Your ref: 3/2018/1014

Date: 23rd January 2019

**Planning Application 3/2018/1014: Listed building consent for repairs/refurbishment works and retrospective consent for works.
5 Gisburn Road Bolton by Bowland BB7 4NP**

Drawing Title
PROPOSED GROUND FLOOR PLAN

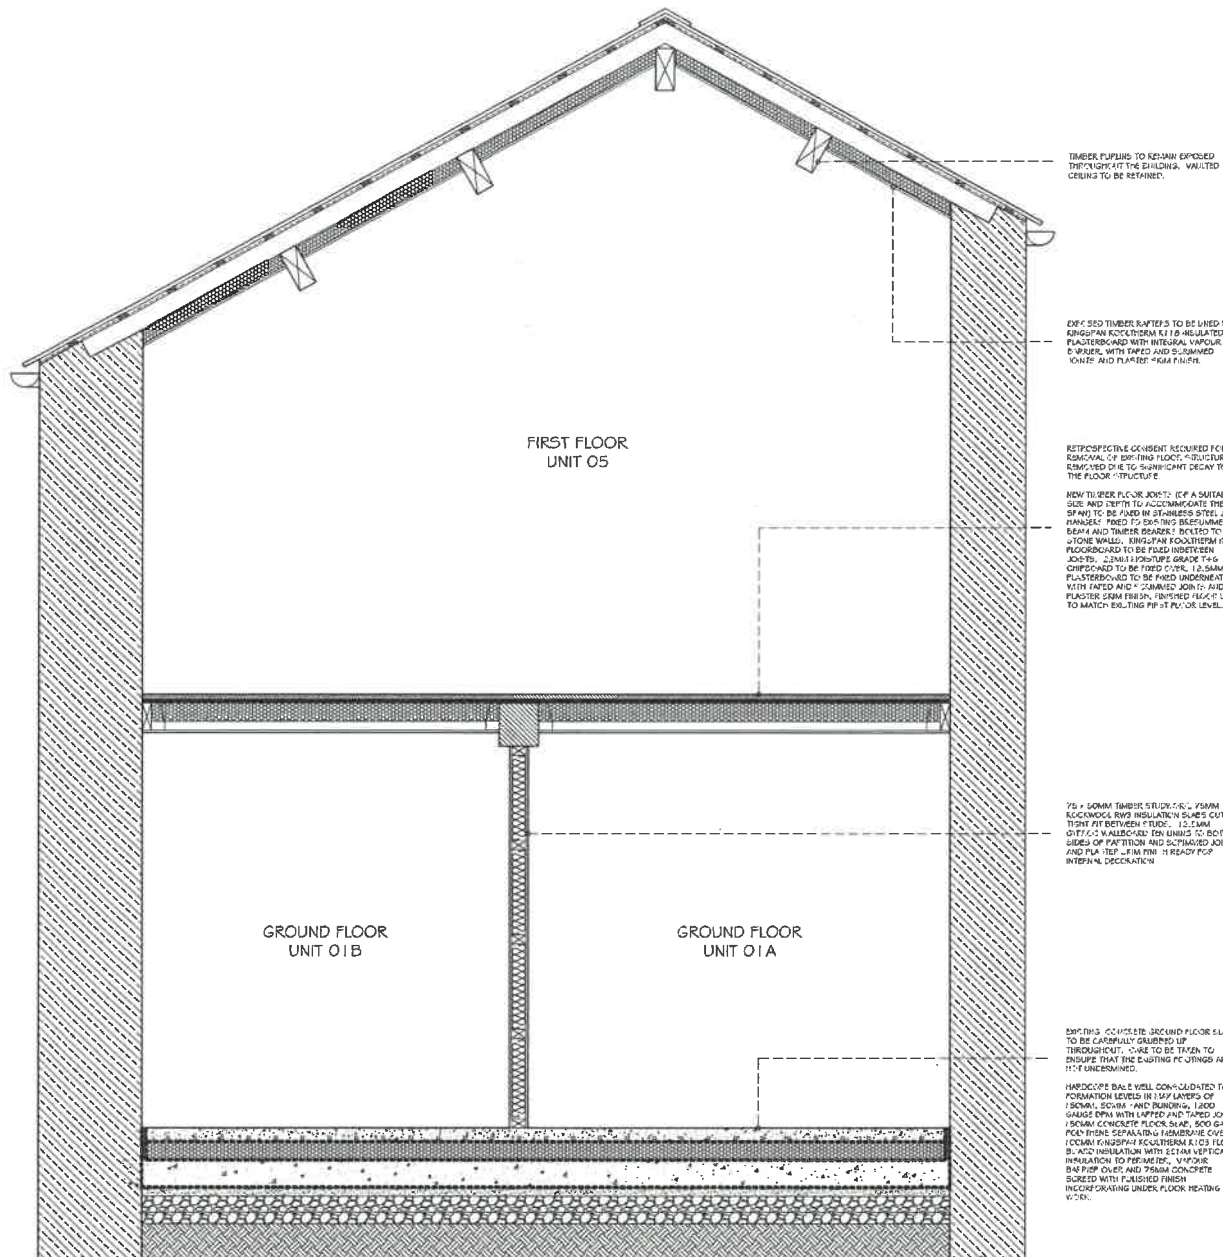
With regard to the replacement floor, as noted in the HS there is a potential for earlier floors to have been covered over by the present concrete, and there is also a significant potential for other buried deposits associated with the construction, use and adaption of the building to have been sealed under it. We would not object to the removal of this later floor however and the suggested mitigation of a formal archaeological watching brief appears to be appropriate. We would ask if consideration has been given to alternative construction methods and materials for the replacement floor, such as limecrete or the use of a suspended floor to introduce a ventilation space, given that a solid floor may drive damp outwards and into the walls. This is, however, a technical design matter which is best dealt with by Mr Dowd and the Architects.

The French drain, intended to reduce the impact of external damp on the walls of the building would appear to be a sensible idea, but it also has the potential to impact buried deposits associated with the construction, use and adaption of the building. We would not object to this proposal and the suggested mitigation of a formal archaeological watching brief again appears to be appropriate.
